From: Harris, Aimee [REDACTED]
Sent: 23 February 2022 12:59
To: Michael Eastham <Michael.Eastham@arun.gov.uk>
Subject: LU/206/21/RES - PHASE 5, HAMPTON PARK

Response to comments received from Carol Reynolds, Senior Environmental Health Officer at Arun District Council (ADC) regarding the submitted Noise Assessment by Tetra Tech [ref 784-B028030 dated 28th April 2021] for planning application reference LU/206/21/RES.

Figure 5.1 Glazing and Ventilation Strategy

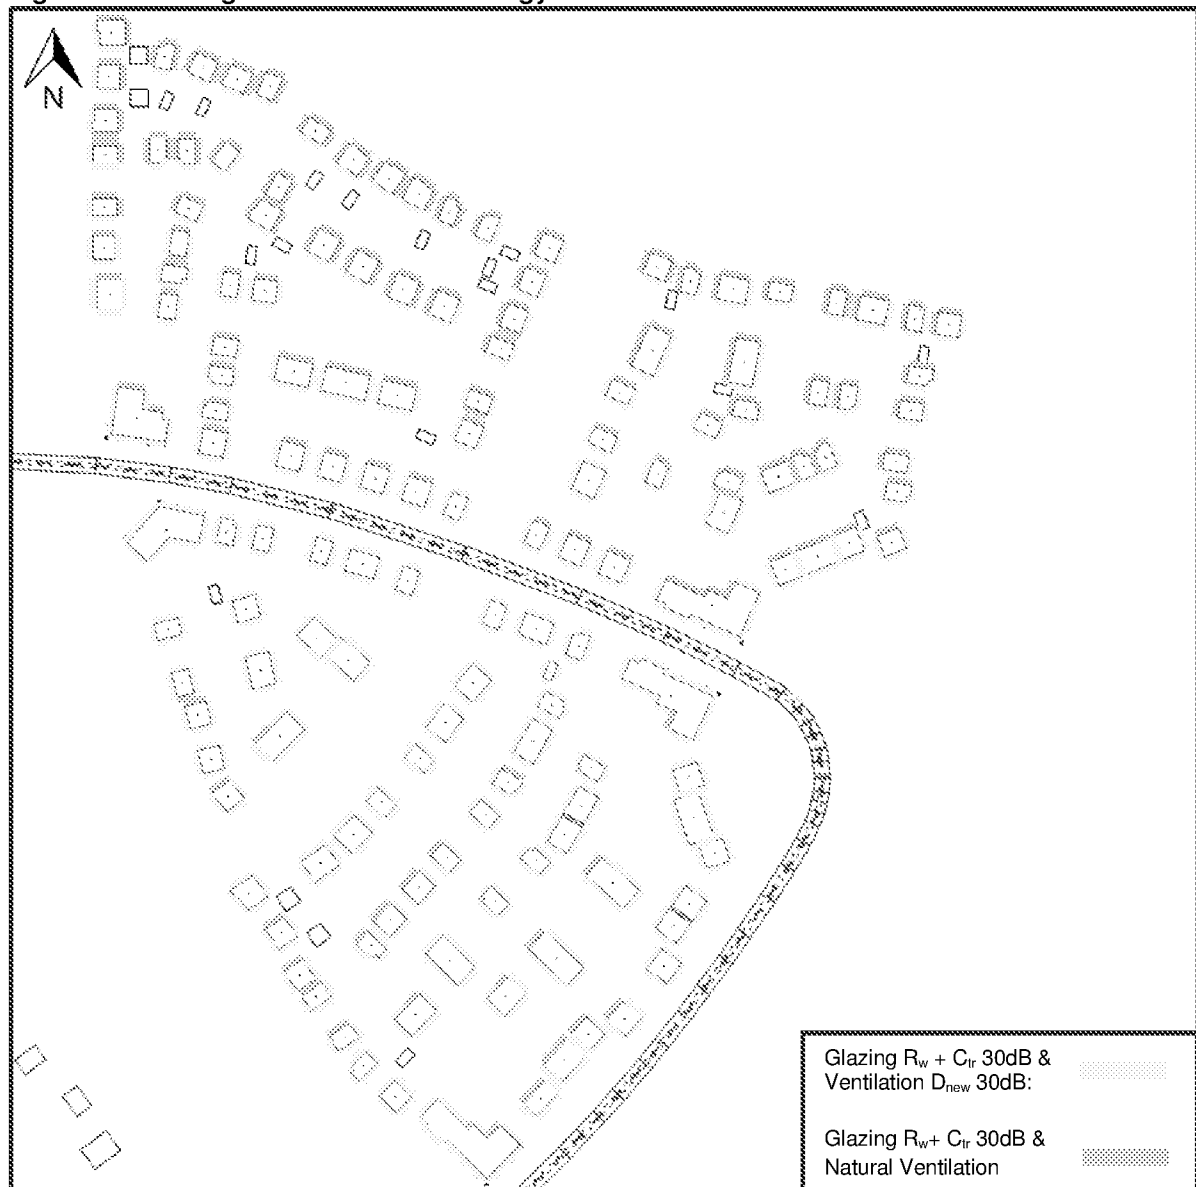
In this case, mechanical means of acoustically treated artificial ventilation should be provided to all adversely effected houses and flats, so that future occupants will have the option of controlling thermal comfort with the windows closed. Such a system should be based on based on MEV3 or 4 as detailed in the Building Regulations, Approved Document F. Whereas the report mentions that mechanical ventilation may be required, this is excluded from Fig 5, Glazing and Ventilation Strategy which only details proposed glazing and passive ventilation.

Within Section 5.1 of the noise assessment, a ventilation specification of D_{new} 30dB is outlined within Figure 5.1 for a number of facades across the site. In order to provide more detailed analysis of the type of ventilation required and assess thermal comfort, the Acoustic, Ventilation and Overheating Guide (AVOG) 2020 has been consulted. This provides guidance for acoustic assessments for residential developments, providing clarity on the relationship between acoustics, overheating and appropriate ventilation requirements. With regards to overheating, AVOG states that as overheating is a temporary condition, during this period "occupants may accept a trade-off between acoustic and thermal conditions, given that they have some control over their environment," and that occupants may "be more willing to accept higher short-term noise levels in order to achieve better thermal comfort."

As shown above, the majority of living room spaces and south-facing facades across the site fall within the Negligible to Low-risk category as defined within the AVOG and therefore as shown within Figure 1 the 'use of opening windows as primary means of mitigating overheating is not likely to result in adverse effect.' Additionally, although not required under the AVOG, acoustic trickle vents are to be installed on a number of living room facades as identified within the noise technical report and combined with the option to open windows, dwellings will be suitable for both thermal and acoustic comfort. Facades exposed to the link road fall just within the Medium Risk category in accordance with the AVOG, however given the predicted levels across the site and given a majority of facades are not south-facing, acoustic trickle vents are considered to be a suitable means of ventilation for these facades.

As shown above, nearly all bedroom spaces and south facing facades across the site fall within the Negligible to Low risk categories in accordance with the AVOG and therefore as detailed within Figure 1, the 'use of opening windows as primary means of mitigating overheating is not likely to result in adverse effect.' Additionally, although not required under the AVOG, acoustic trickle vents are to be installed on a number of living room facades as identified within the noise technical report and combined with the option to open windows, dwellings will be suitable for both thermal and acoustic comfort. Facades exposed to the link road fall just within the Medium Risk category in accordance with the AVOG, however given the predicted levels across the site and given a majority of facades are not south-facing, acoustic trickle vents are considered to be a suitable means of ventilation for these facades.

An example of acoustic trickle vents which achieve the minimum specification of D_{new} 30dB are Titon's SF Xtra Sound Attenuator Vent where details are presented in Appendix A.
